Application for a Non-Material Amendment Following a Grant of Planning Permission

Householder Application - Erection of 1.5 storey side and rear extension and first floor extension to bungalow. Raise roof level with alterations to fenestration including 3no dormers to front elevation.

DC/22/03656

Title: Proposed Elevations and Section

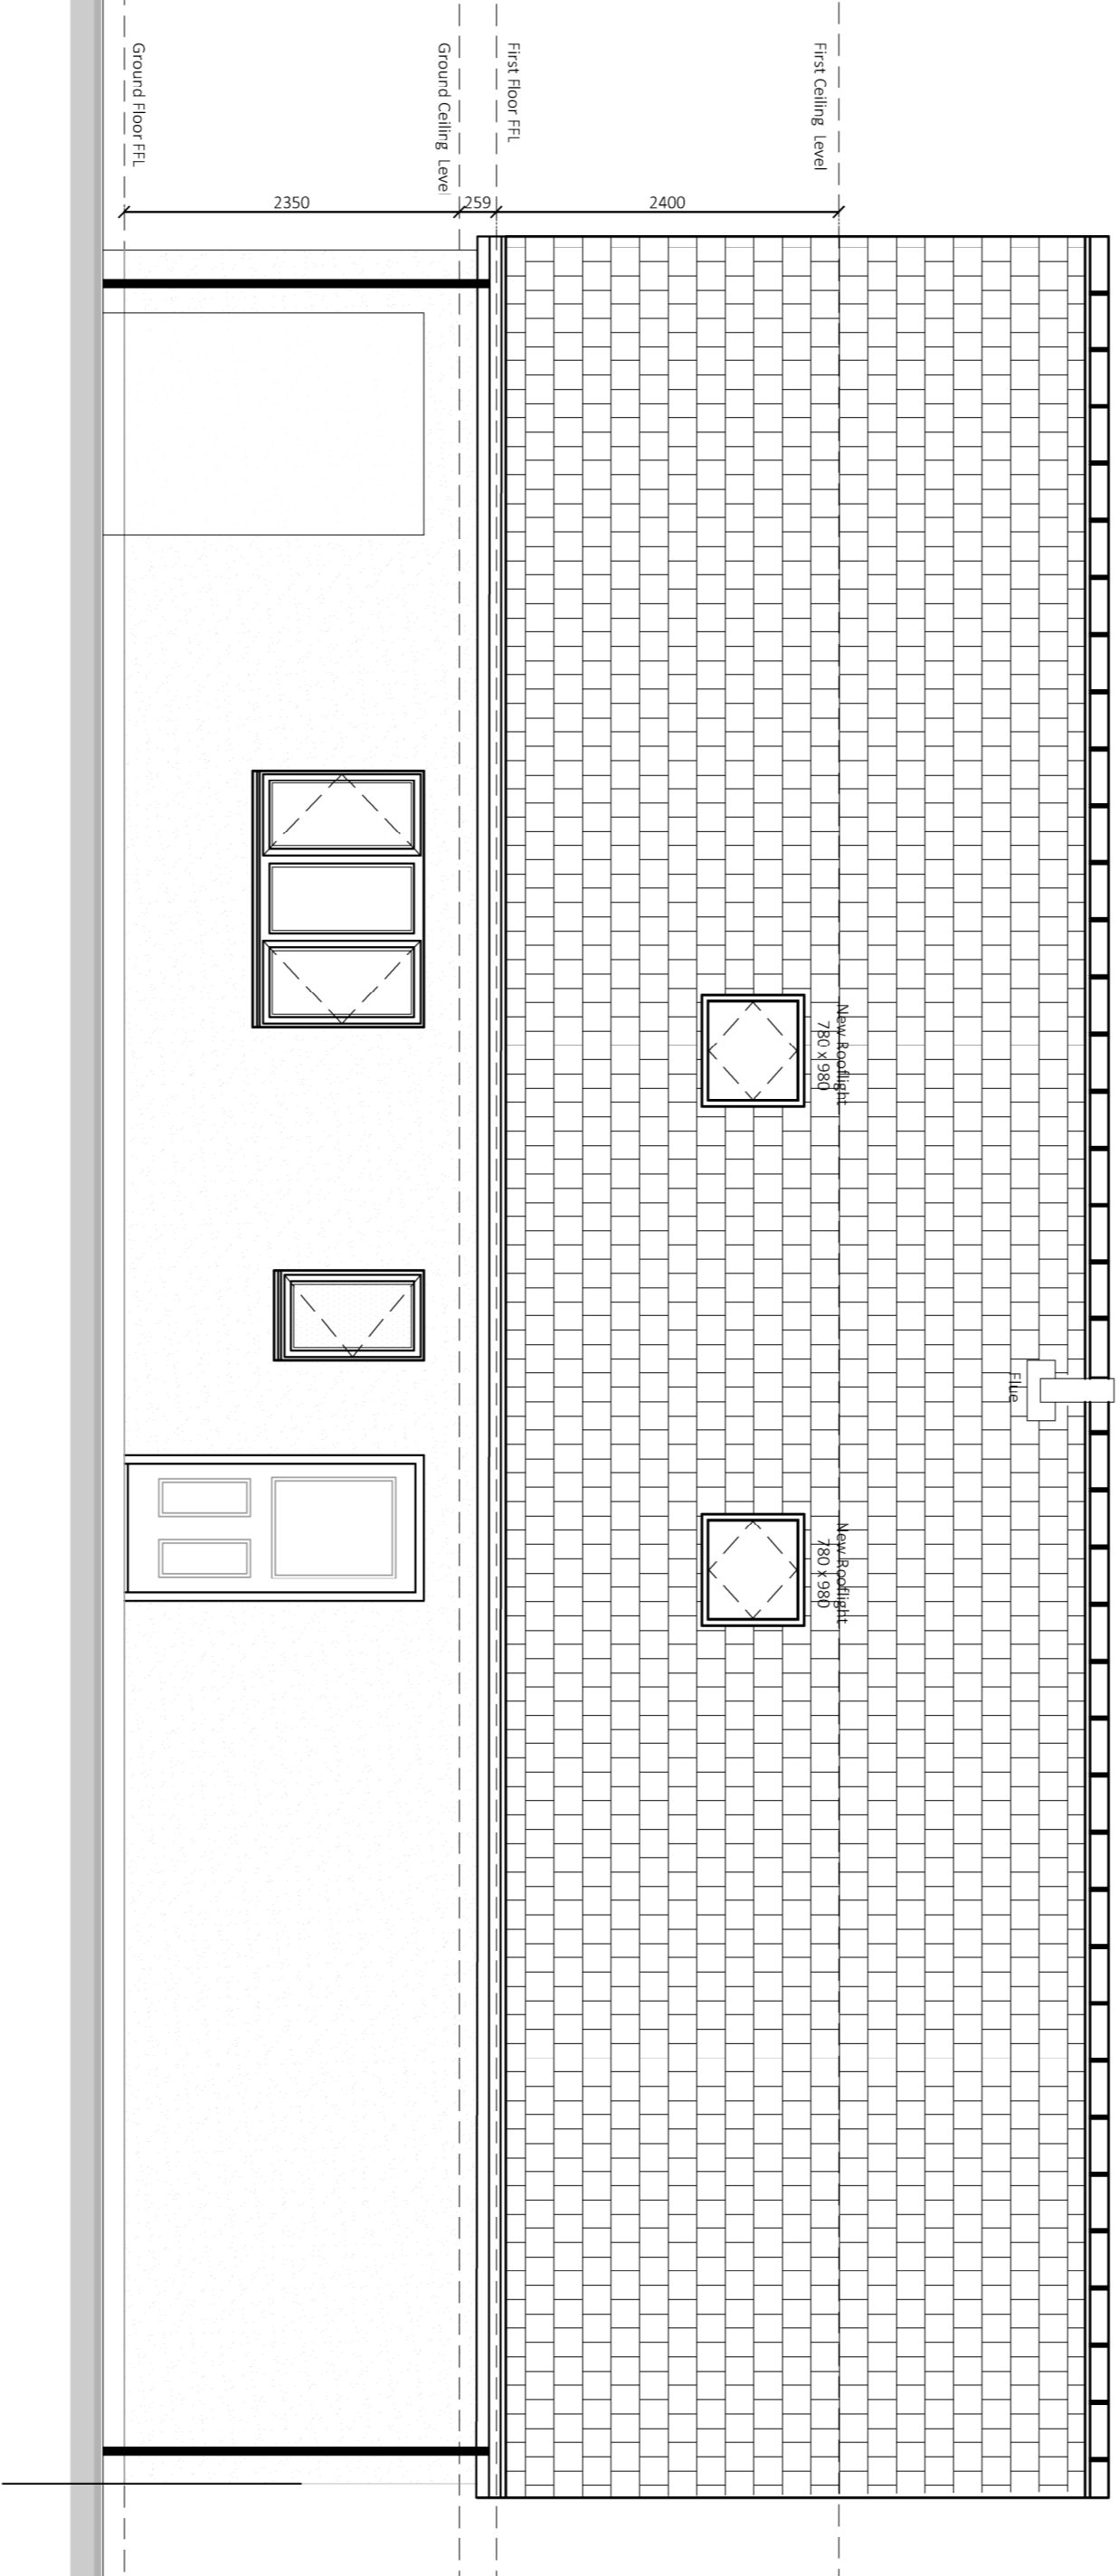
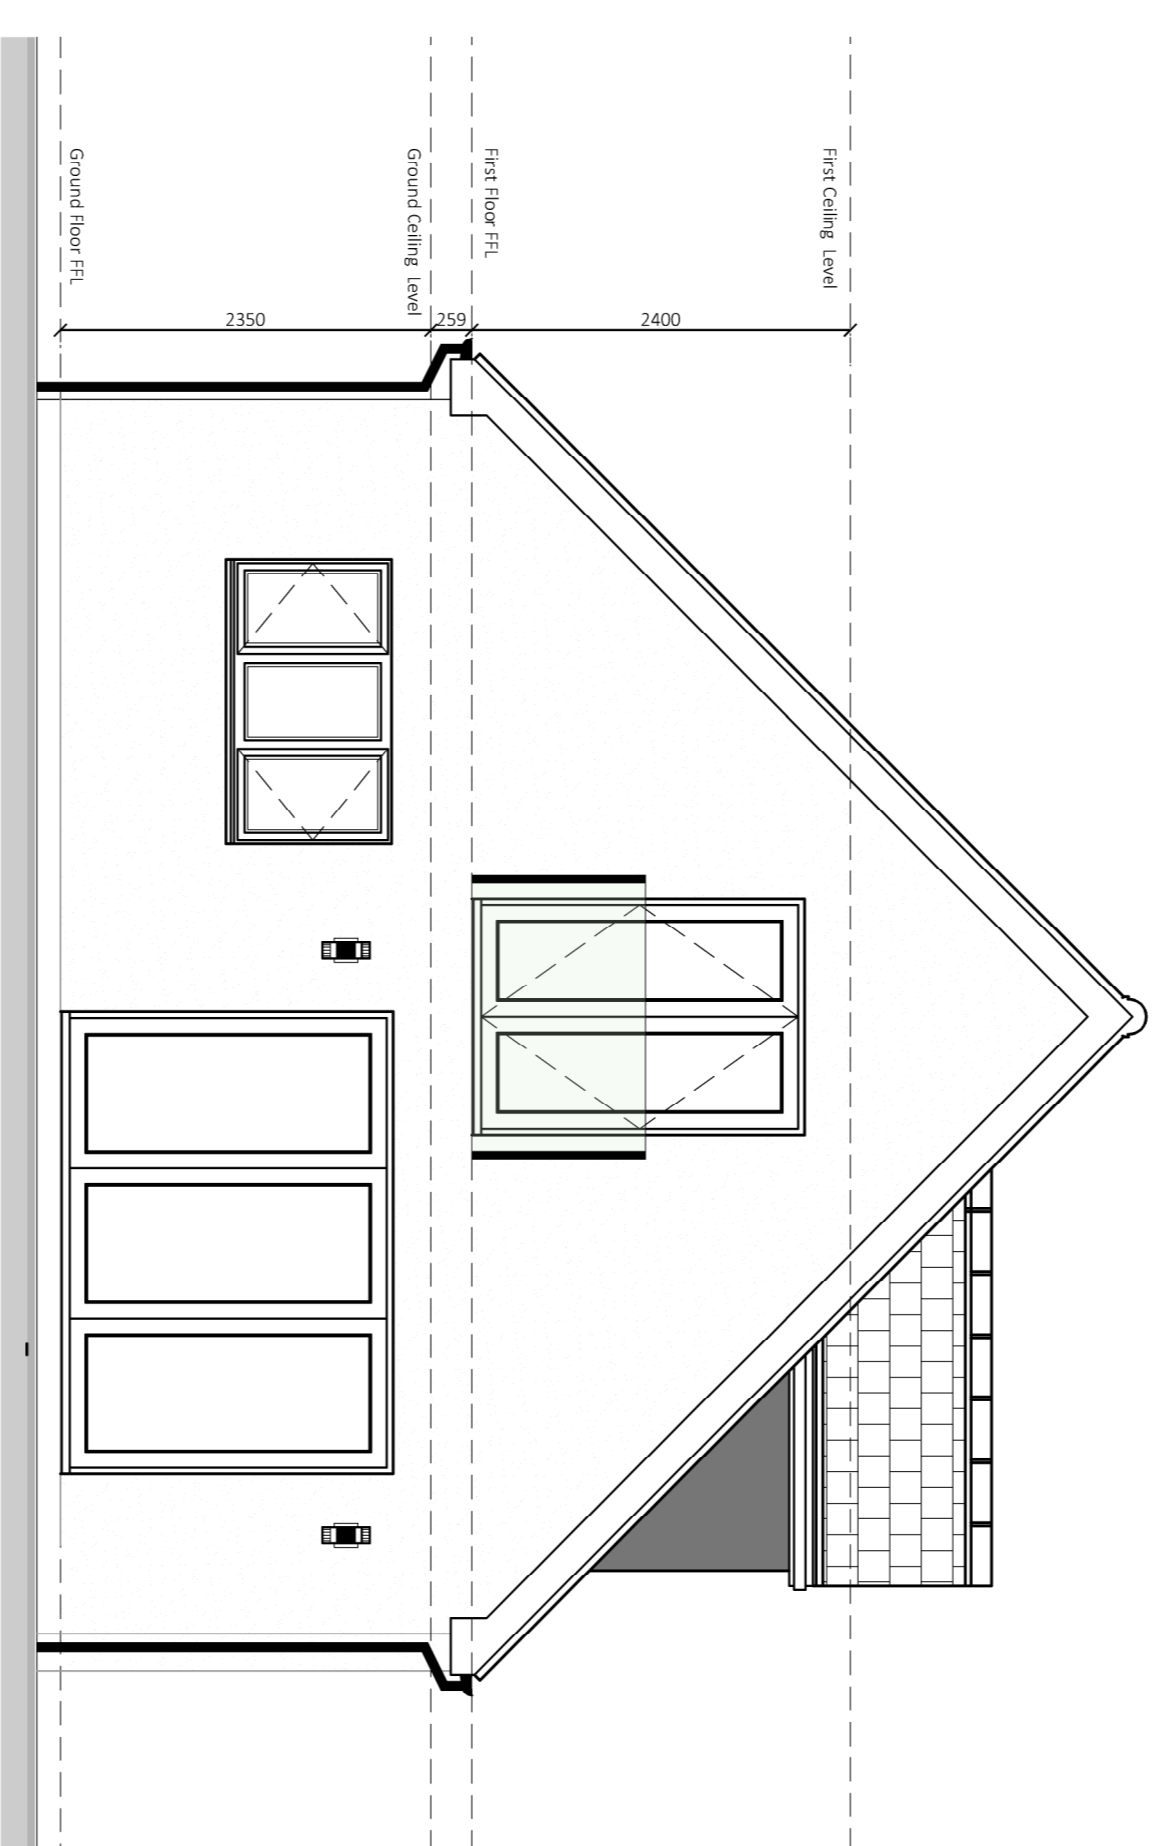
Ground floor amendments comprising minor alterations to internal kitchen, dining and utility arrangement.
First floor amendments; Bedroom 4 replaced with 1500 x 2100 french doors complete with glass Juliette balustrade.
Roof Plan no amendments.
North Elevation (Front) no amendments.
West Elevation (Side) no amendments.
South Elevation (Rear) 3 pane sash window removed, 2 Pane sash window replaced with rear door to Utility.
East Elevation (Side) Window and door configuration at ground floor adjusted to suit internal layout, 2 Pane double door replaced with 3 pane sliding patio doors. At first floor 2 pane ssh window replaced with 1500 x 2100 french doors complete with glass Juliette balustrade.
Landscaping adjusted to provide hard landscaping to new rear access door.
Section A-A no amendments
